**Re: Main Bank  
7300 Menaul Blvd., NE  
Request for Certificate of Occupancy- Transportation Development  
DRB Approval date 1-28-15 (H19-D055A)  
Certification dated 3-20-16**

RE: **Main Bank, (File: H19D055A)**  
**Grading & Drainage Plan, Engineer's Stamp Date 3-12-2015**  
**Supplemental Calculations, Engineer's Stamp Date 3-12-2015**

RE: **Main Bank**  
**Grading & Drainage Plan**  
**Engineer's Stamp Date 1-23-2015 (File: H19D055A)**

**Re: Main Bank Conceptual Grading and Drainage Plan  
Engineer's Stamp Date –no stamp- (H19D055A)**

Drawing file: H19D055A / 2072 CG-101 CONCEPTUAL-GRADING & DRAINAGE PLAN.pdf

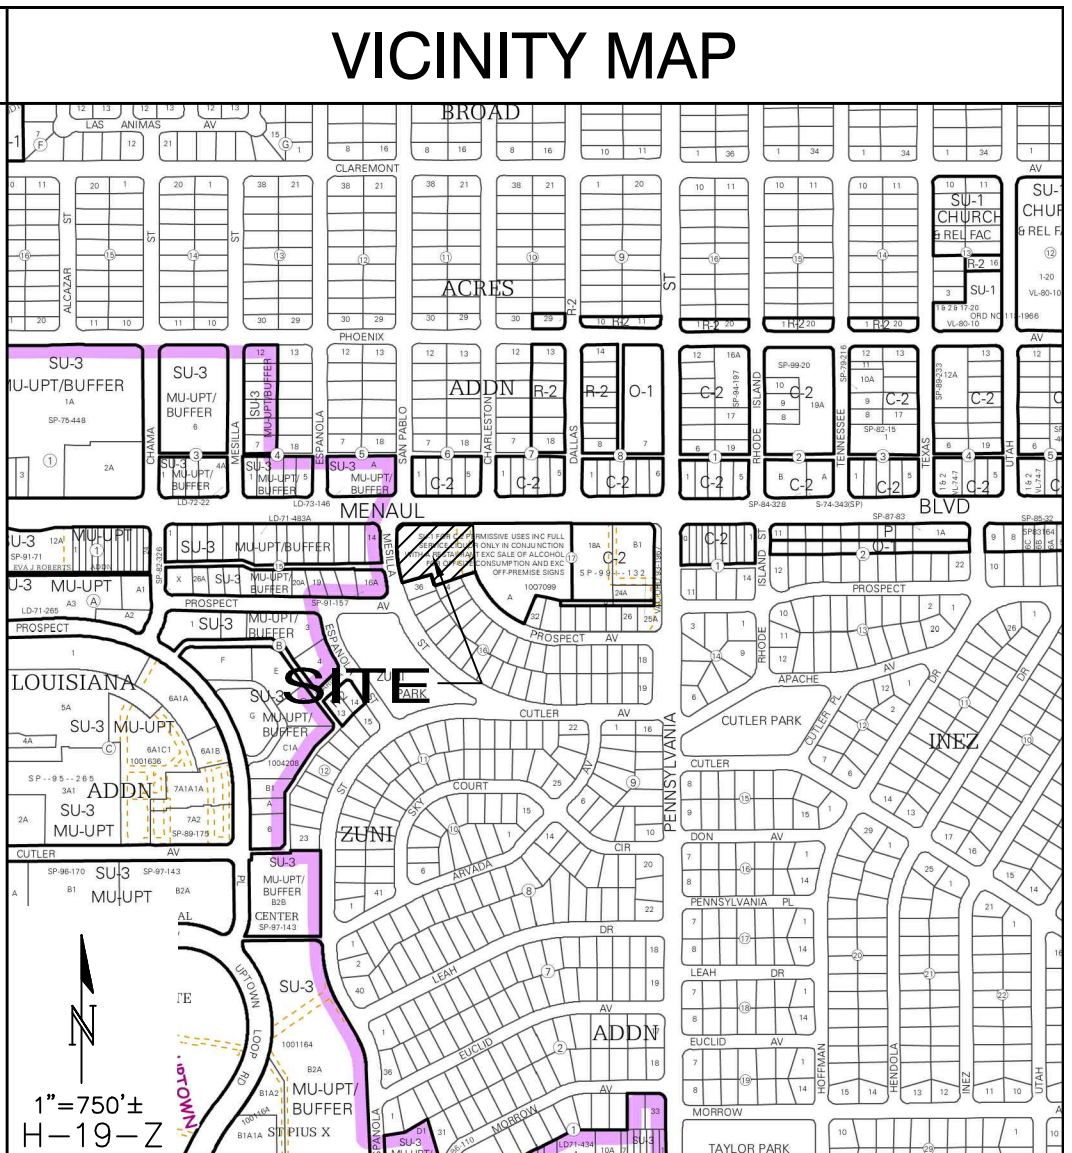
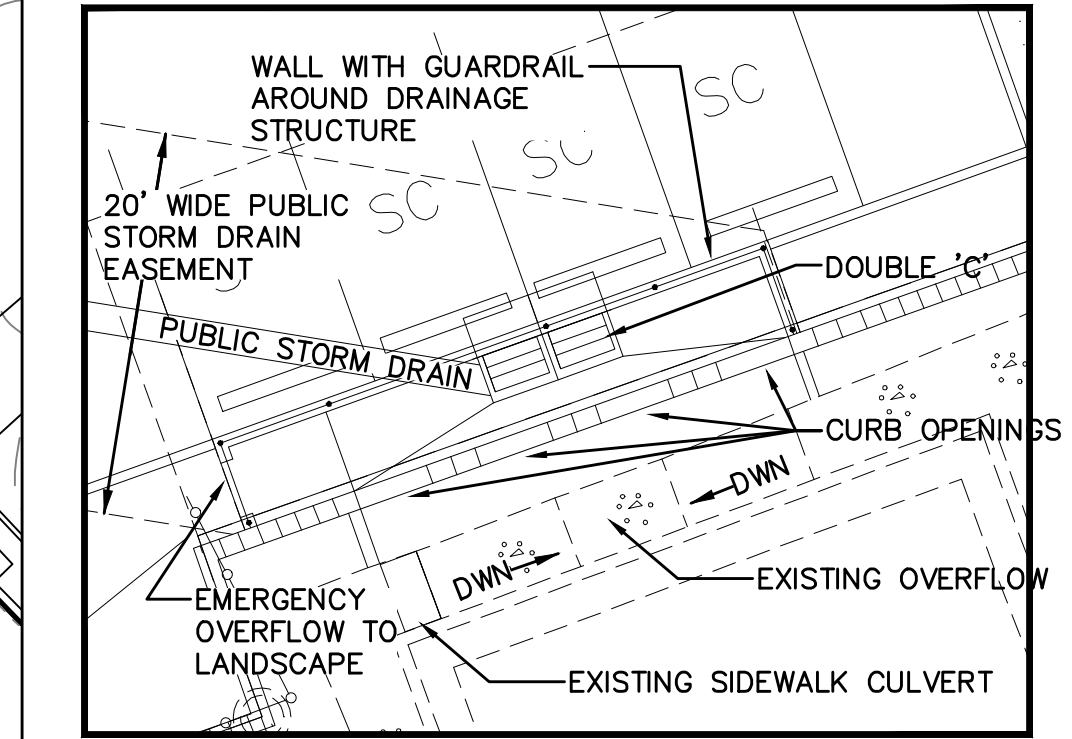
Based upon the information provided in your submittal received 10-30-14, the above referenced plan cannot be approved for Site Plan for Building Permit action by the DRB until the following comments are addressed:

1. The plan proposes to direct the stormwater leaving Prospect Ave in a 90 degree angle. This is not hydraulically favorable, may increase the depth and create a wave in the cahnnel.

This may work. DB's not appear hydraulically  
favorable where flows go thru wall and hit  
channel wall head on. Also hard to believe  
channel is cheaper than 24" pipe.

Based upon the information provided in your submittal received 11-14-14, the above referenced plan is approved for Site Plan for Building Permit action by the DRB with the following condition: the area between the sidewalk culvert/walk-dip section and the inlet will be concrete and included in the DRC construction plans.
